Consultation Response from: KC Environmental Health (Pollution & Noise Control)

2025/92088 - Land off, Bankwood Way, Birstall Retail Park, Birstall, Batley, WF17 9DT

Discharge of details reserved by conditions 9 (retaining walls), 18 (Remediation Strategy) on previous permission 2024/91591 for variation of conditions 2-6, 15 and 29 of previous permission 2021/92528 for erection of retail development, associated parking, servicing areas and landscaping

Date Responded:
8th June 2026

Drawing Reference
1080.07 Fig1

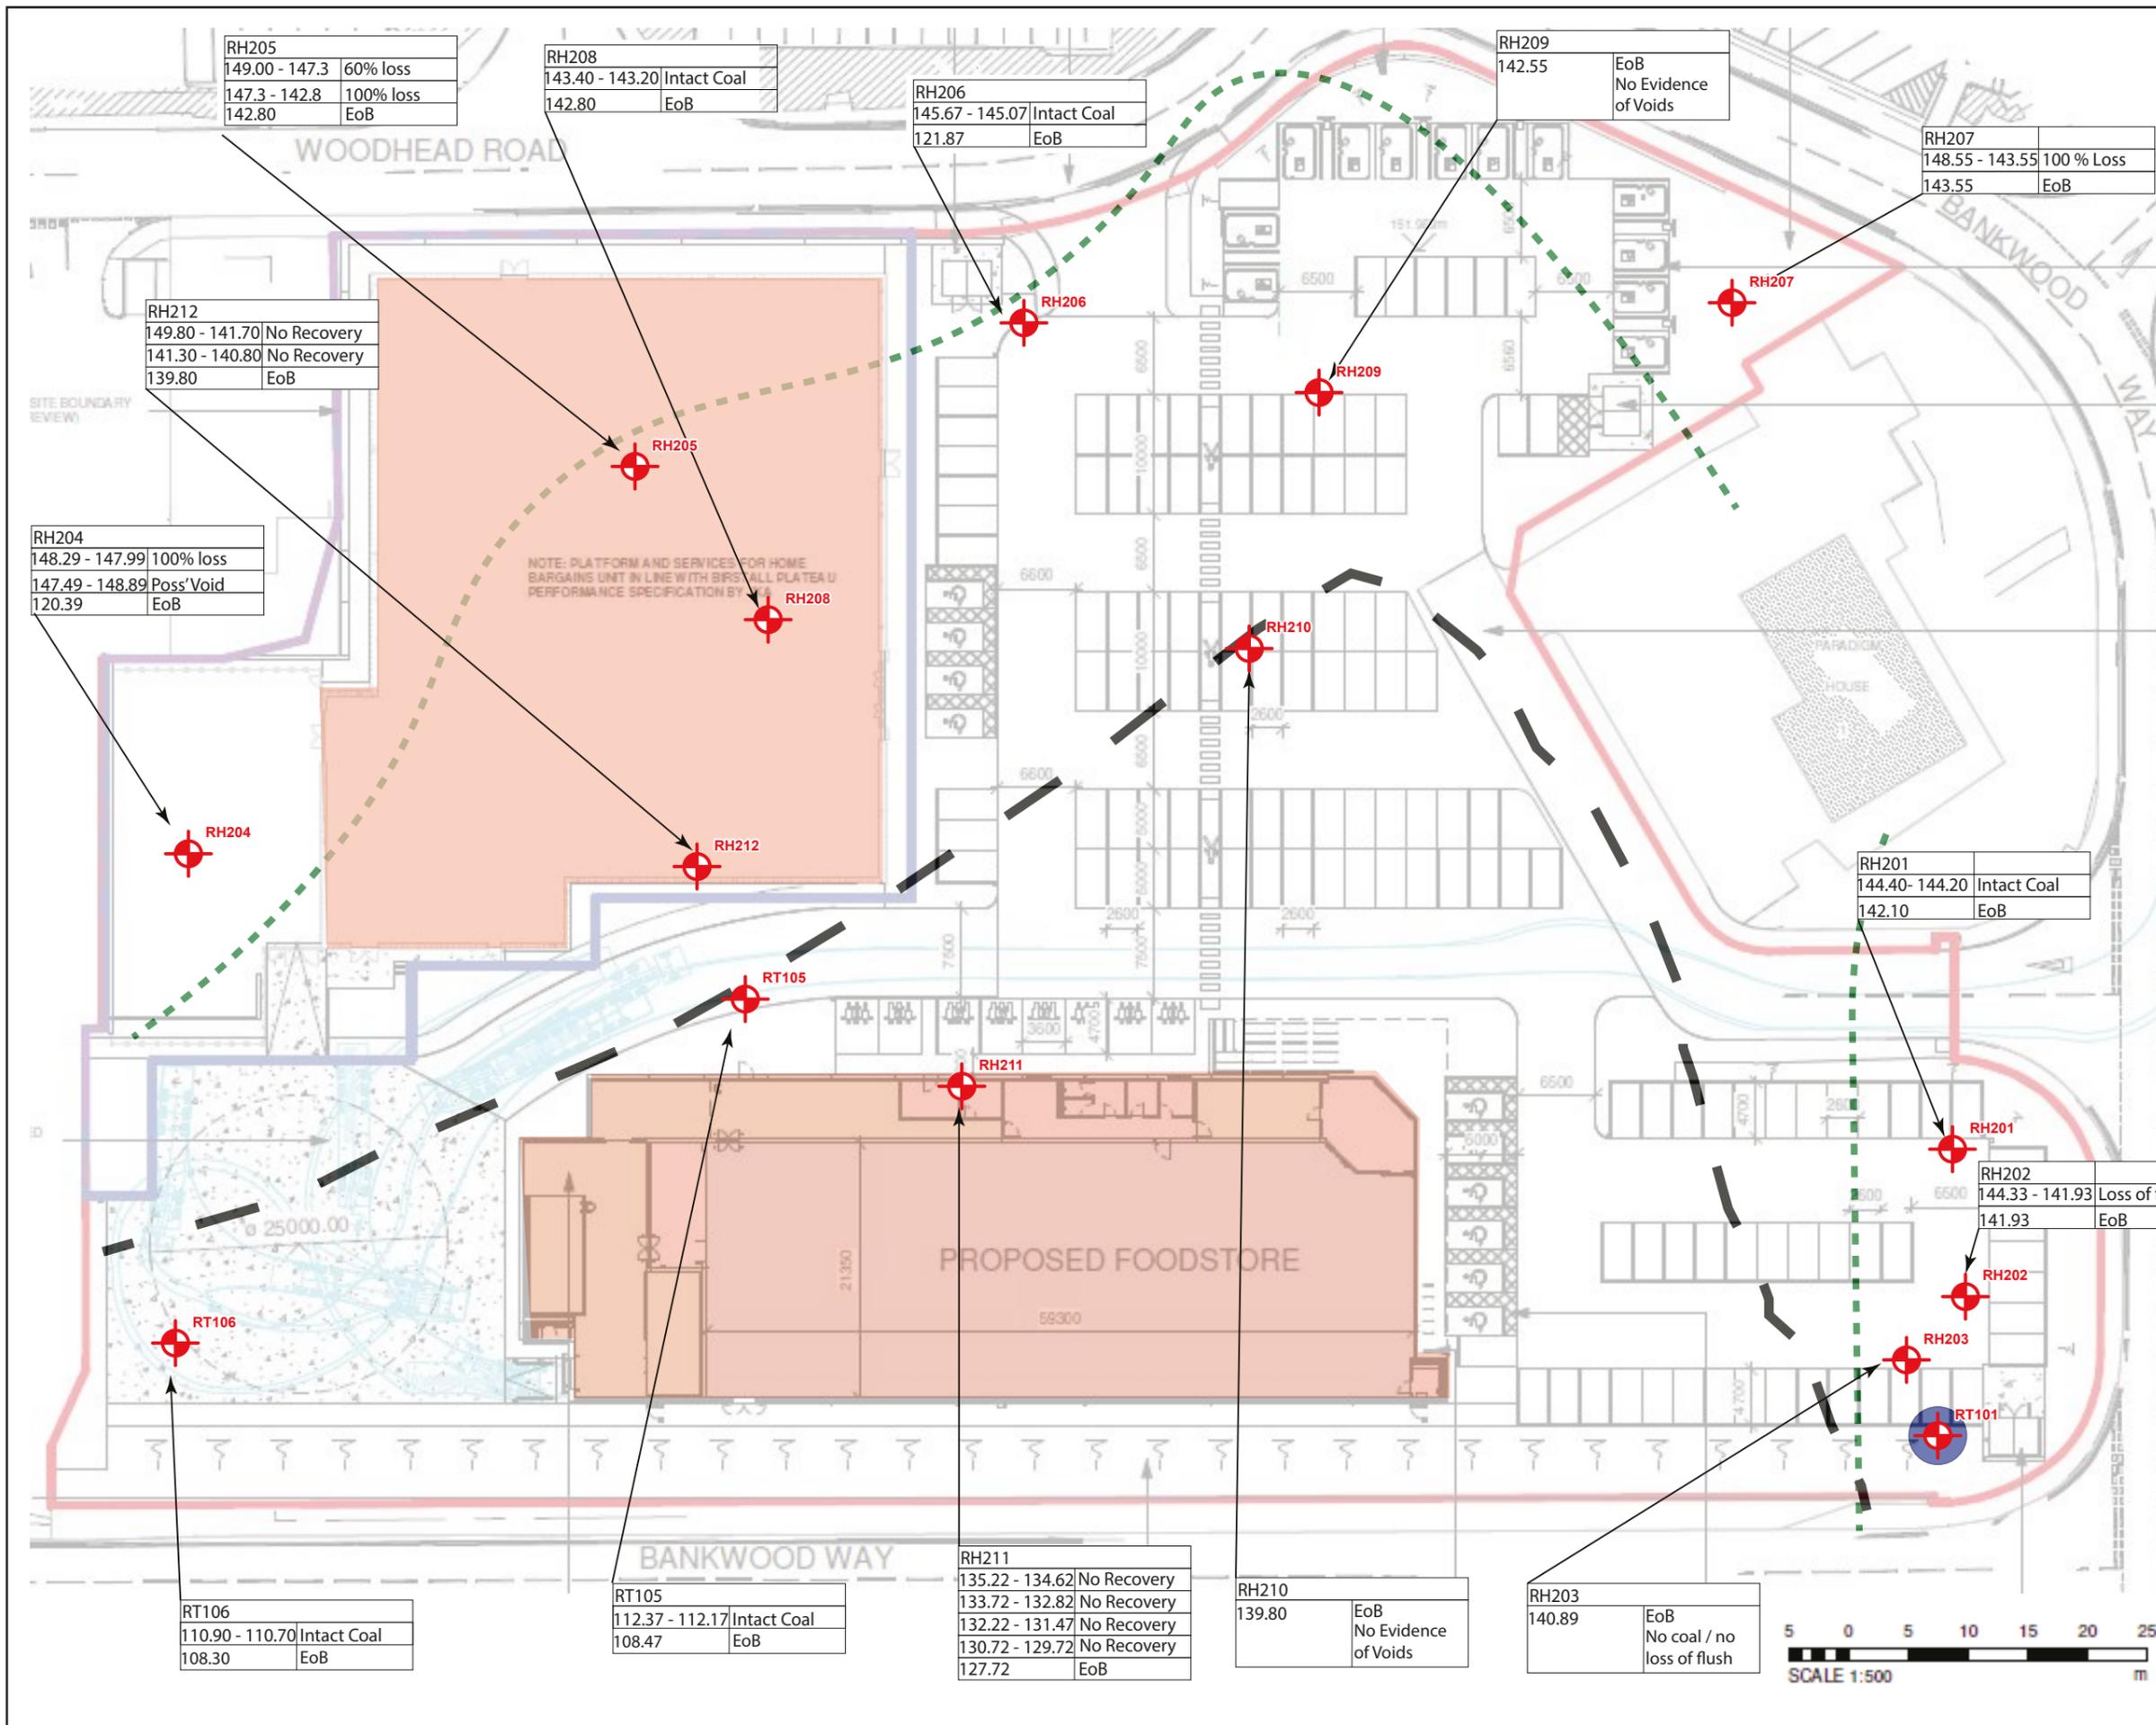
Section 4 of the above report presents the Remediation Outline Method Statement. The section begins by stating that *A summary of remediation activities with cognisance to the proposed site layout is shown in Figure 1*. Figure 1 is Drawing “1080.07 Fig1”, this drawing states that here will be a *Site-wide turnover to 1.5m bgl*, again contradicting previous information.

SDS Ground Improvement Plan

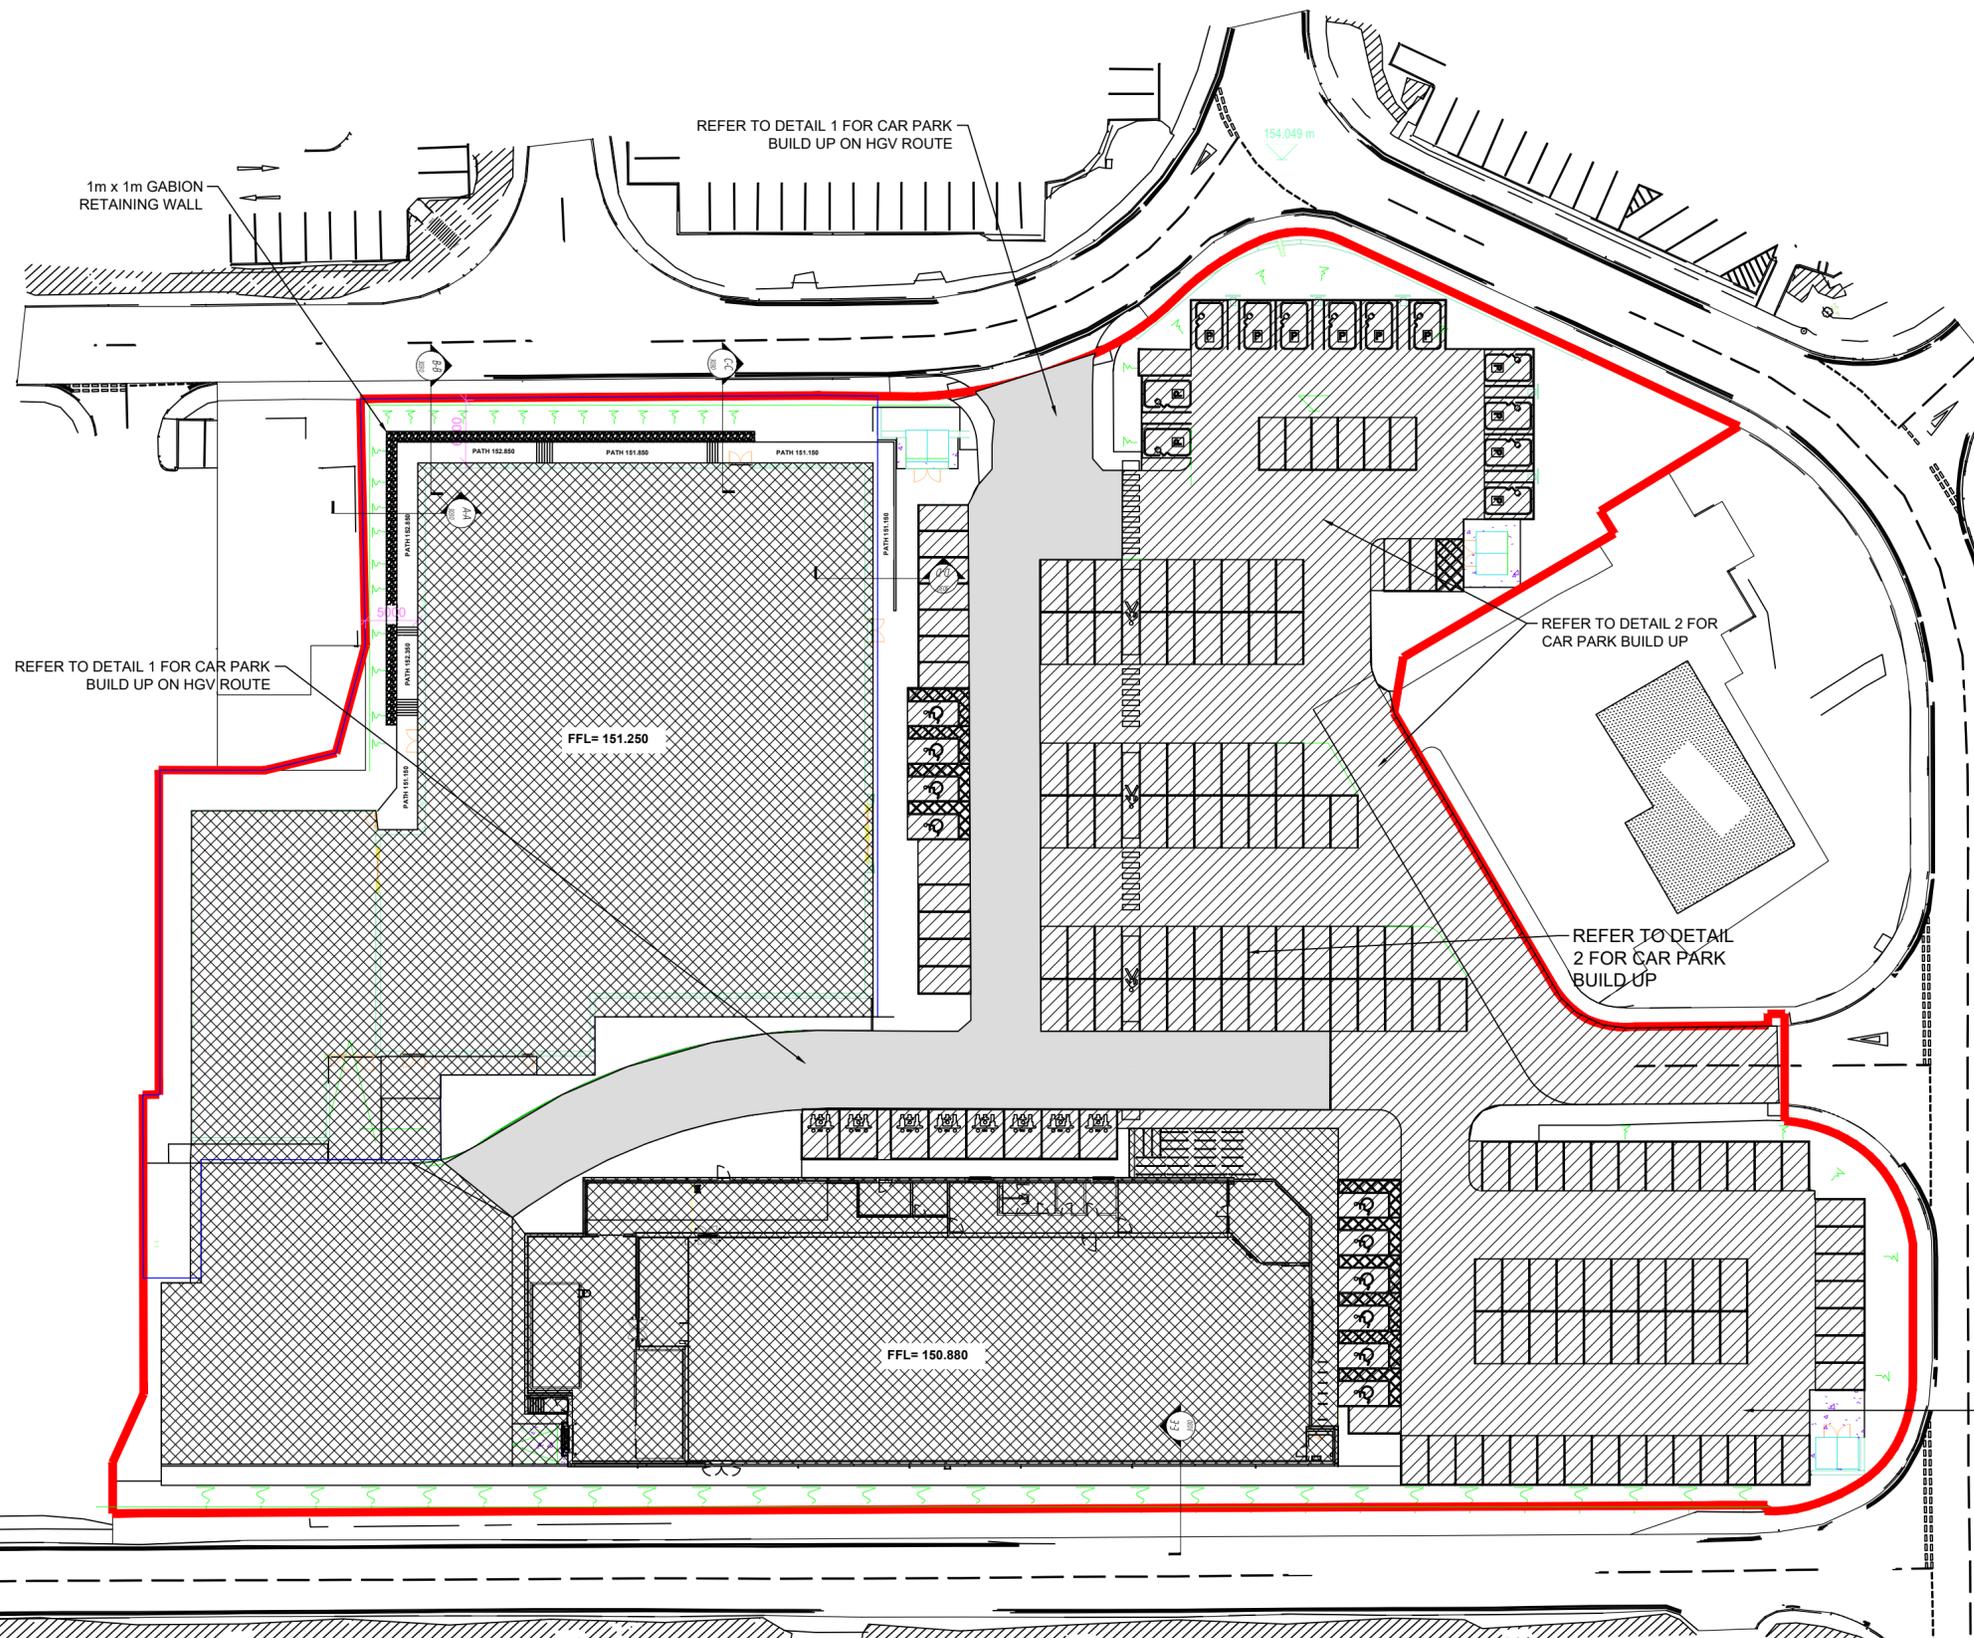
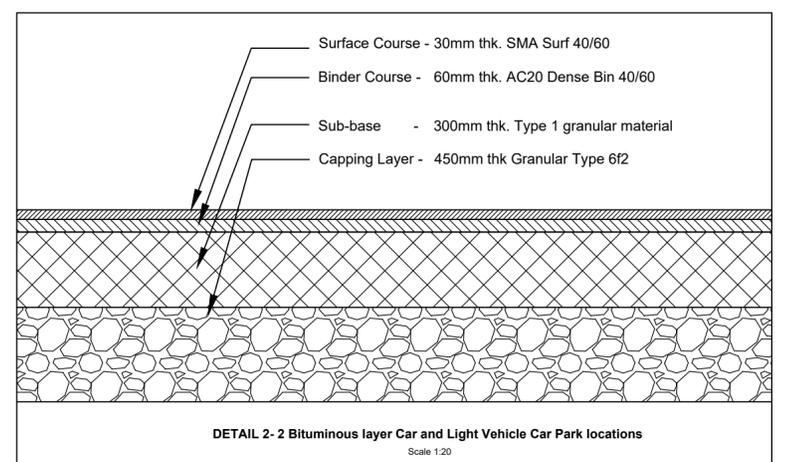
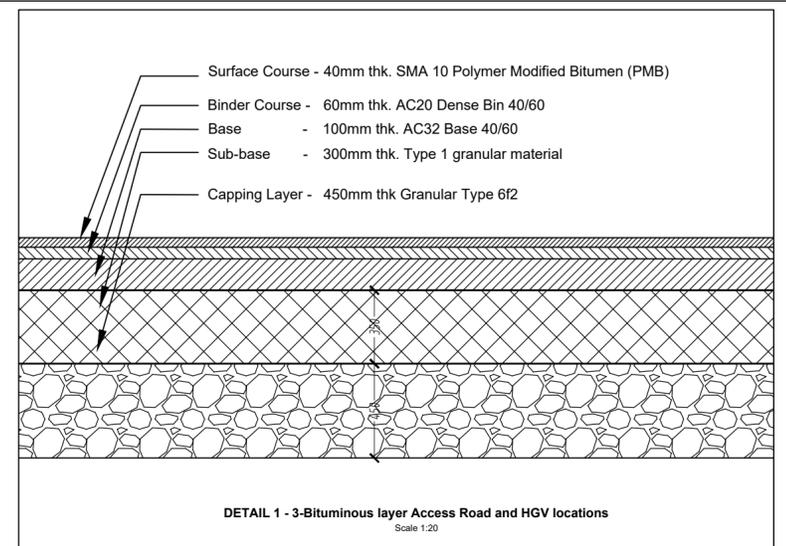
Section 4.6 “*Foundations and Ground Improvements*” of the report states: *“Ground improvement will be undertaken in accordance with SDS Ground Improvement Plan (drawing ref. 22254-3010-T1, included as Appendix C). The works are summarised below:*

- *Vibro stone columns underneath building footprints to achieve the minimum bearing capacity specified by the engineer, currently 150kPa; and*
- *Construction of the capping layer will be undertaken as indicated on the SDS Ground Improvement Plan (Appendix C) as a 450mm layer across the site. The piling mat will be constructed as per the contractor’s requirements, which are to be confirmed.*
